NCFMP and NCDOT MOA Project Review

Project TIP / ID:	B-4950
WBS:	40108.1.1
Initial Submittal Date:	9/28/2016
MOA Approval Target Date:	12/30/2016
Project LET DATE:	5/16/2017
DOT Project Manager:	Paul Atkinson
DOT Design Engineer:	Craig A Freeman
In-House or PEF project?	PEF
PEF (Name of Firm)	RS&H Architects-Engineers
DOT STR. INV. # (6-digit):	250171 and 250172

Stream Name :	South River
River Basin :	Cape Fear
Regulating City:	N/A
Regulating County:	Cumberland, Sampson
Division:	06
Community ID Number:	370076
Latitude (in decimal degrees):	35.0527
Longitude (in decimal degrees):	-78.6565
Route Number:	SR 1851
Road Name (on FIRM Panel):	Faircloth Bridge Rd
Effective FIS date:	7/17/2007
Panel Number (4-digit):	1406J
Panel Effective Date:	1/5/2007
Published section # up/down stream	3740/3480

GENERAL DRAWING
BRIDGE 172 ON SR 1851
OVER SOUTH RIVER
BETWEEN SR 1848 & SR 1424

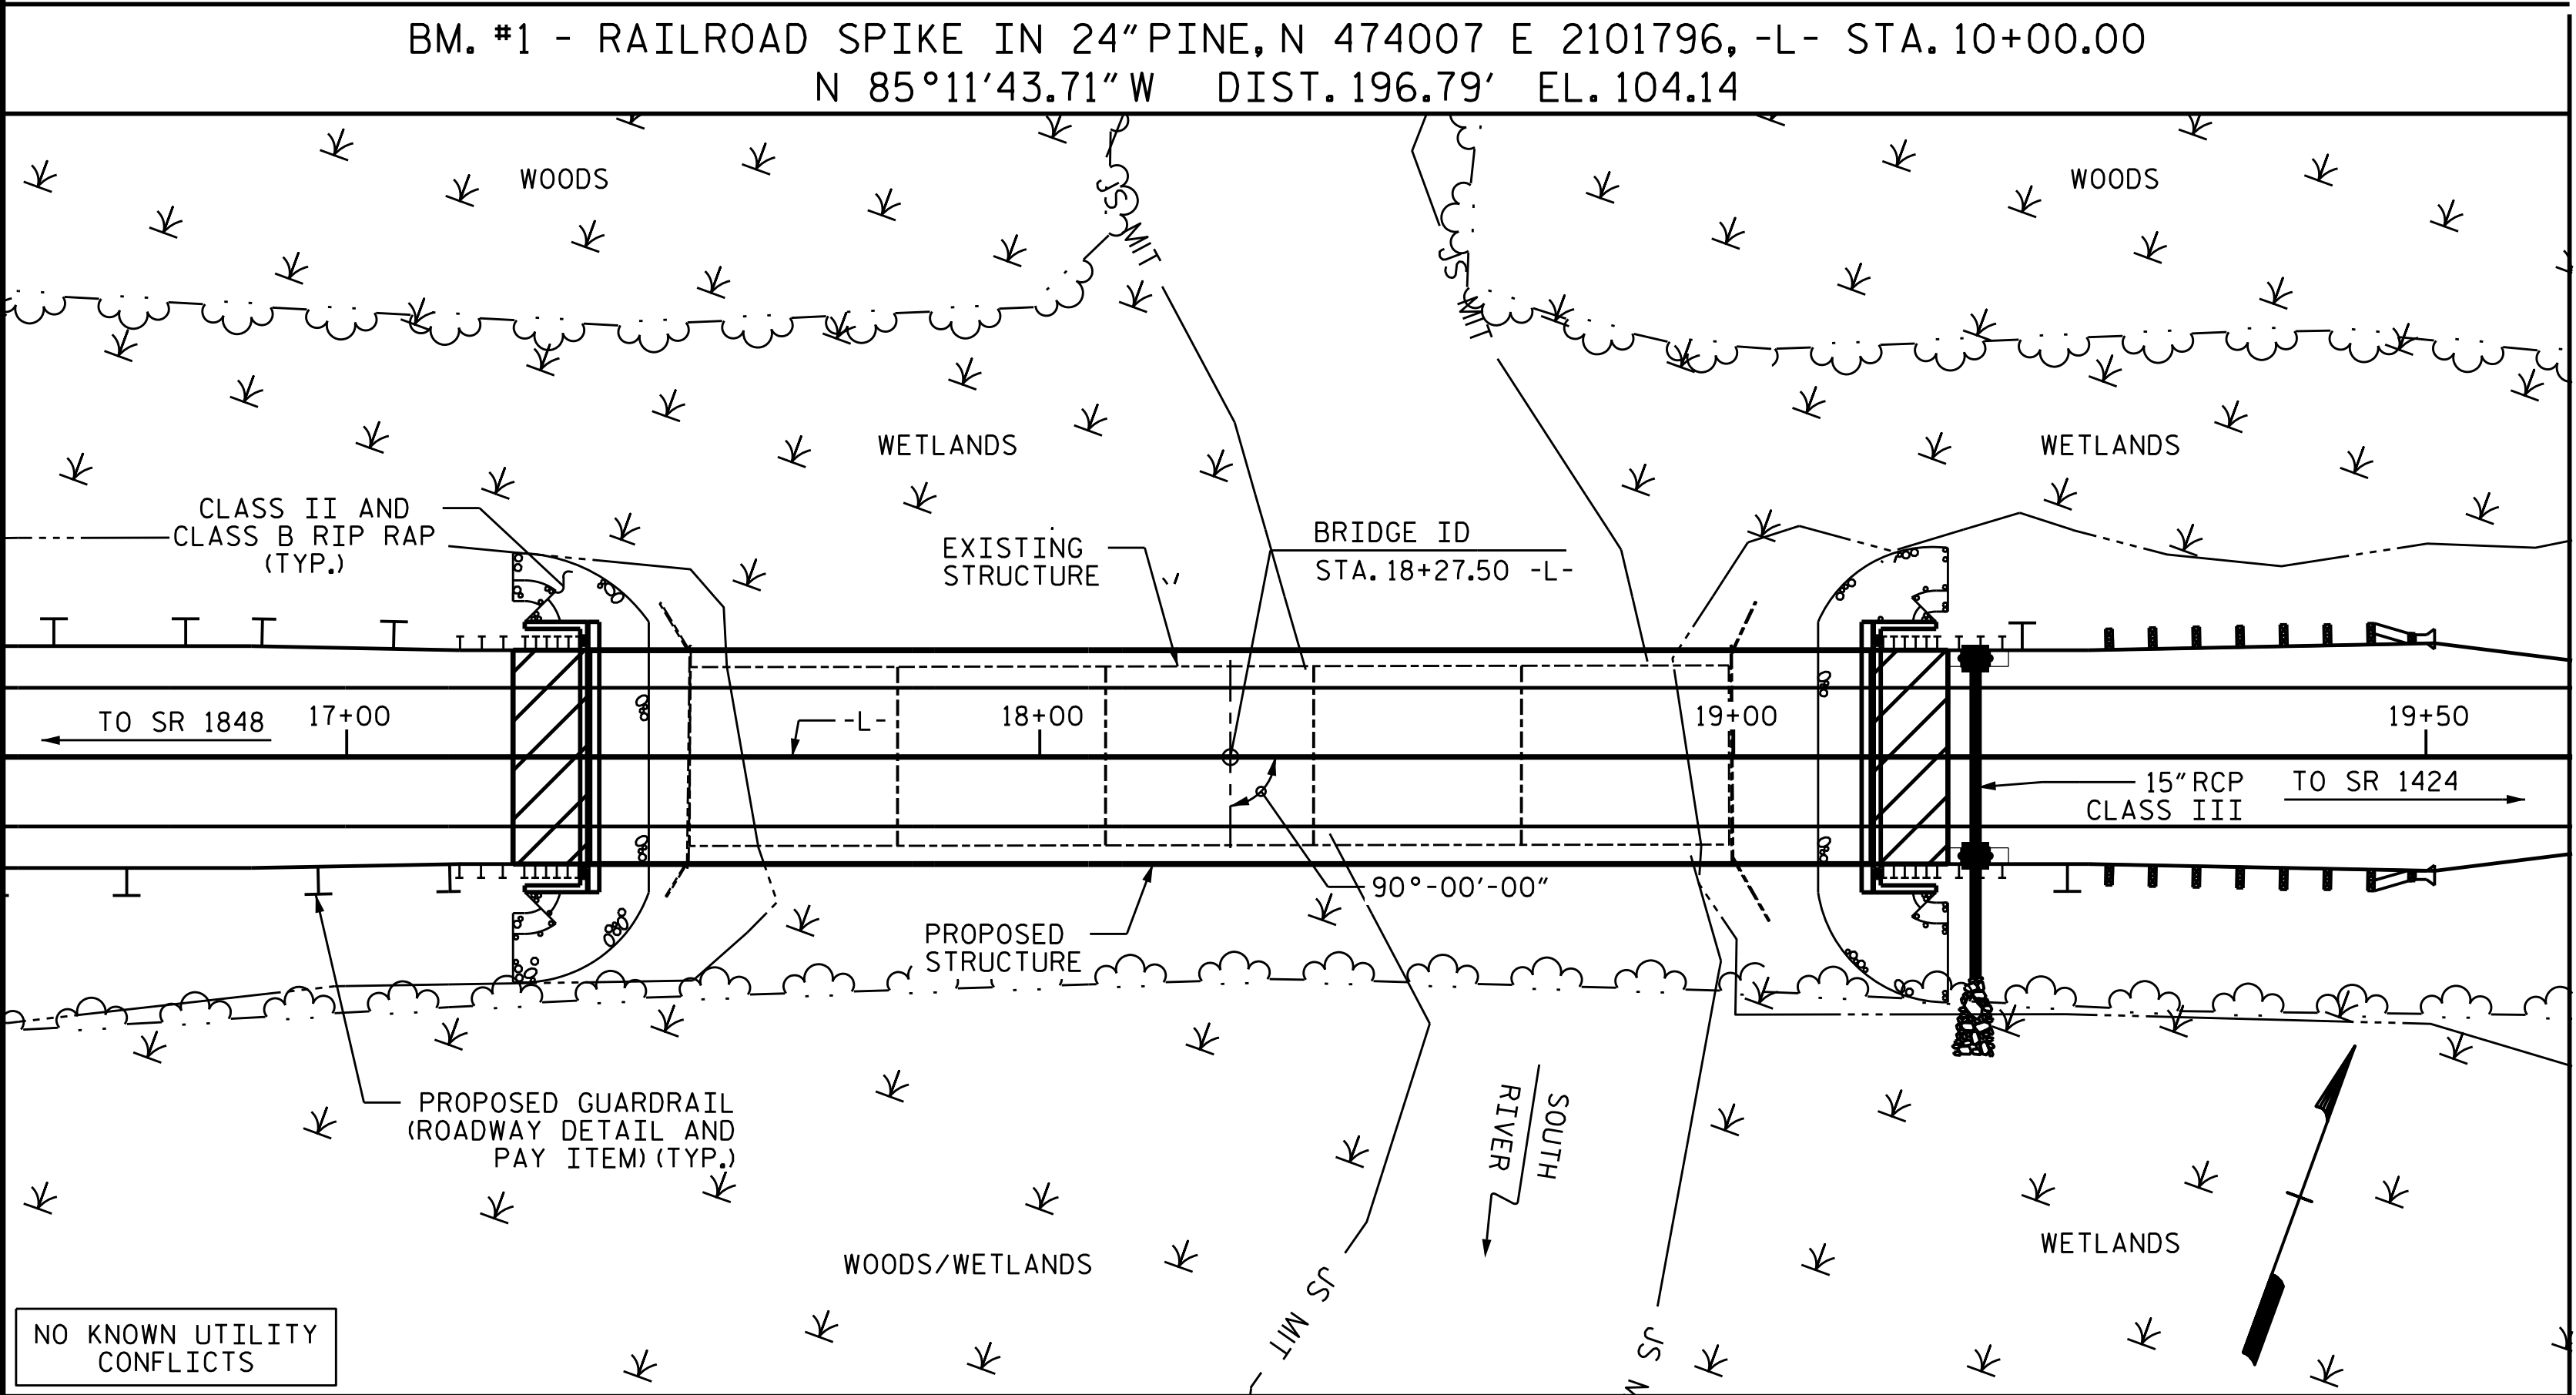
Per the Narrative, the total length of Bridge 250171 is 122.25'; but the BSR shows its spans as 1@35', 1@55', 1@30' making the total length as 120'. Similarly, the total length of Bridge 250172 is 187.25' per the Narrative, but the BSR shows its spans as 1@35', 2@55', 1@40' making the total length as 185'. Please verify the total span and effective span of both bridges in the models and the Narrative and revise as necessary. The Narrative mentions that both bridges have 3' diameter interior bents in the Revised Model, but the Drag Coefficient for Bridge #2 has been set as 2.0; please revise it as 1.2 for circular piers as appropriate.

5. For Bridge 250172, the existing bridge low chord and high chord elevations do not exactly match the elevations shown on the BSR. The modeled bridge deck elevations are approximately 0.2 ft to 0.5 ft lower than the elevations shown on the BSR. Please check and revise if necessary.

Model Narrative Revised to match the BSR. Total length for bridge 0171 and 0172 changed to 120' and 185' respectively, and the effective span was verified as the total bridge length less end bents. Our oversight on the drag coefficient for Bridge #2 was revised to 1.2. Additionally the pier shape coefficient for Bridge #2 was revised to 0.9 for semi-circular nose and tail. Model was rerun and the output did not change.

The existing bridge low chord elevation was verified based on NCDOT survey data elevations. The bridge deck elevation has been changed to accurately reflect the field survey data and match the bridge deck on the BSR.
